**From:** [REDACTED]  
**Sent:** 19 October 2018 16:03  
**To:** Charlotte Bodin  
**Subject:** Re: Planning application for 26 Beaumont Park (Ref: LU/257/18/HH)

Following our phone conversation yesterday, a copy of the location and block plan are being posted back to you for you to outline the site in red. As you are proposing a crossover, you also need to include the pavement in front of the property within the red line.

Drawing Title:
Existing and Proposed Site Plans

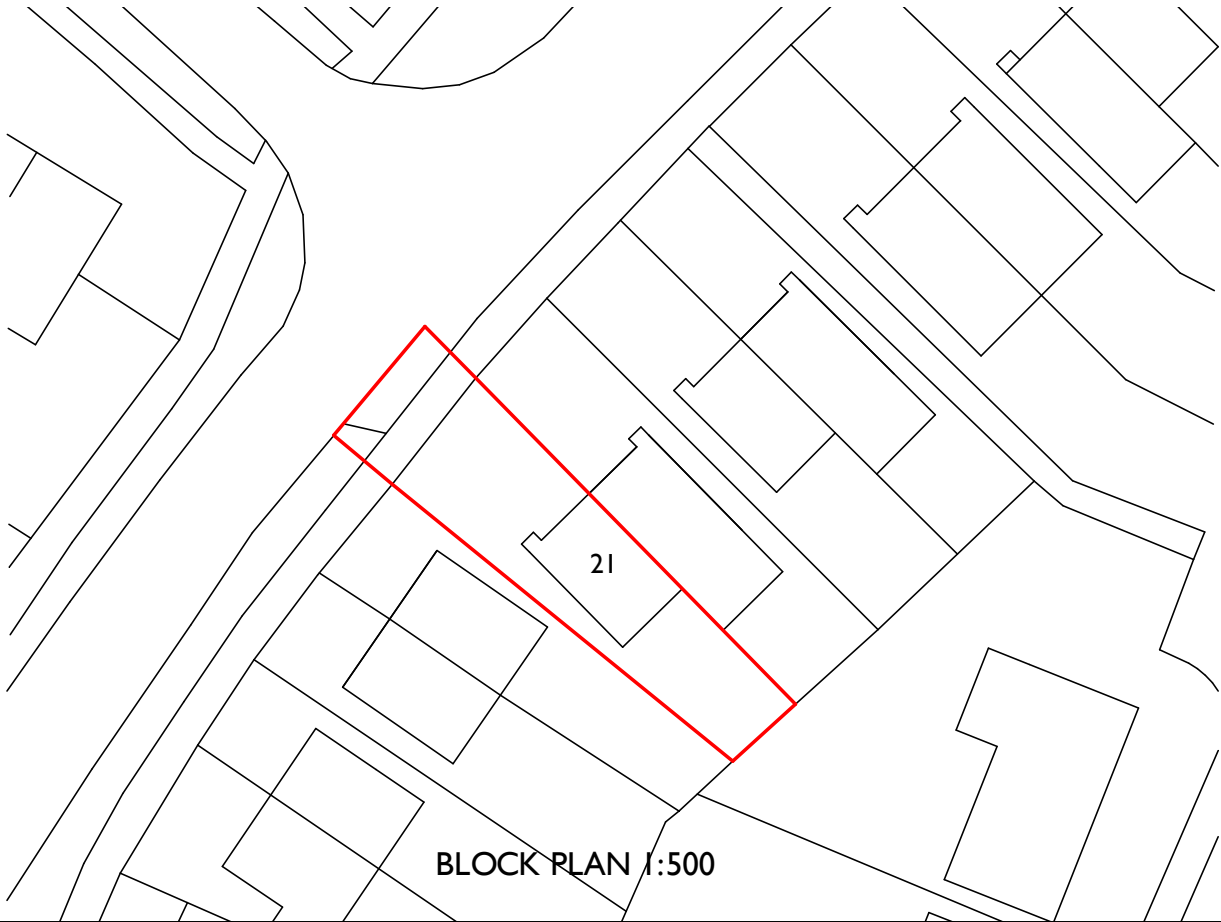
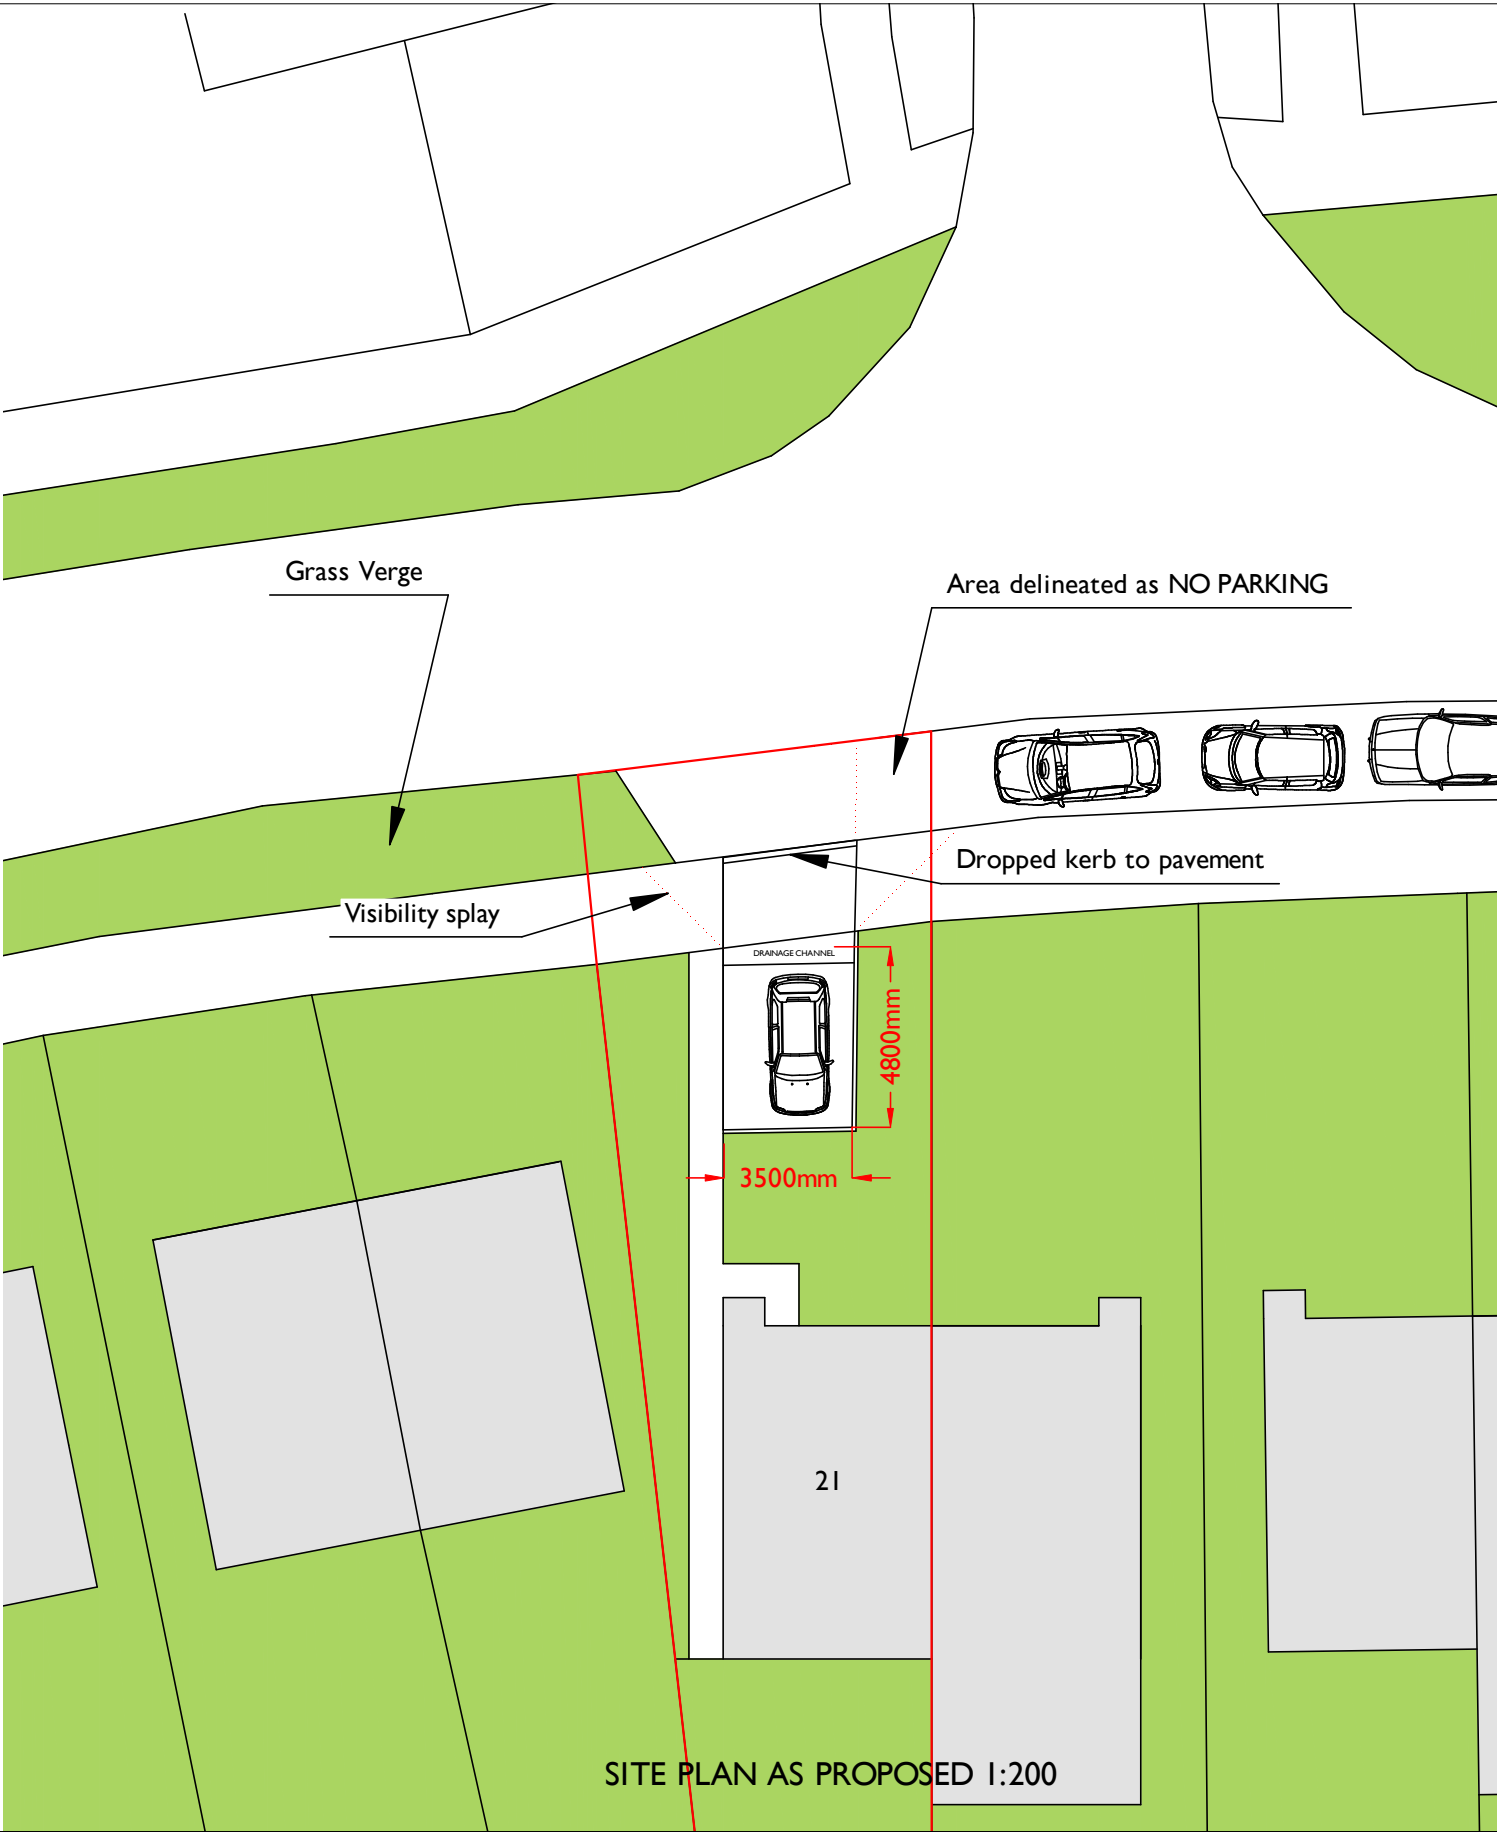
It has been confirmed that you do need to provide a scaled site plan to show the proposed driveway and drop kerb, and also that you need to show the visibility splay on a plan. A visibility splay is formed by measuring to a point 2.4m back from the carriageway in the centre of the driveway or entrance. A line (70m long in the case of a 30mph limit) is then drawn to the right, to a point where it strikes the near-side edge of the carriageway.
